Please ask for: Ms Iqraa Malik
Email: iqraa.malik@terraquest.co.uk
Telephone: 01212341390
Our Ref: AB/116/20/HH
Your Ref:
Date: 6th November 2020

Application for Planning Permission for Works or Extension to a Dwelling

Development: Proposed single storey rear extension to replace conservatory
Location: 42 Fitzalan Road Arundel BN18 9JS

Proposed Rear (North-West) Elevation

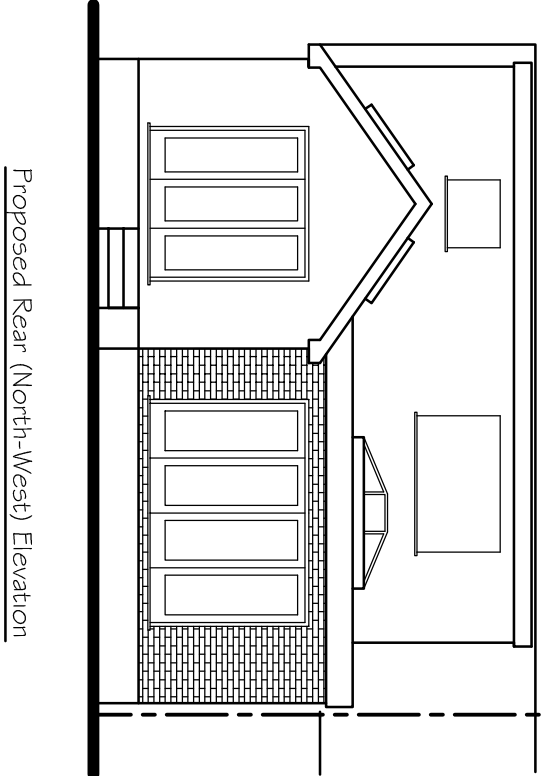
Proposed Rear Elevation

The proposed rear elevation has been labelled as the existing rear elevation. Please amend.
CIL Additional Information Form
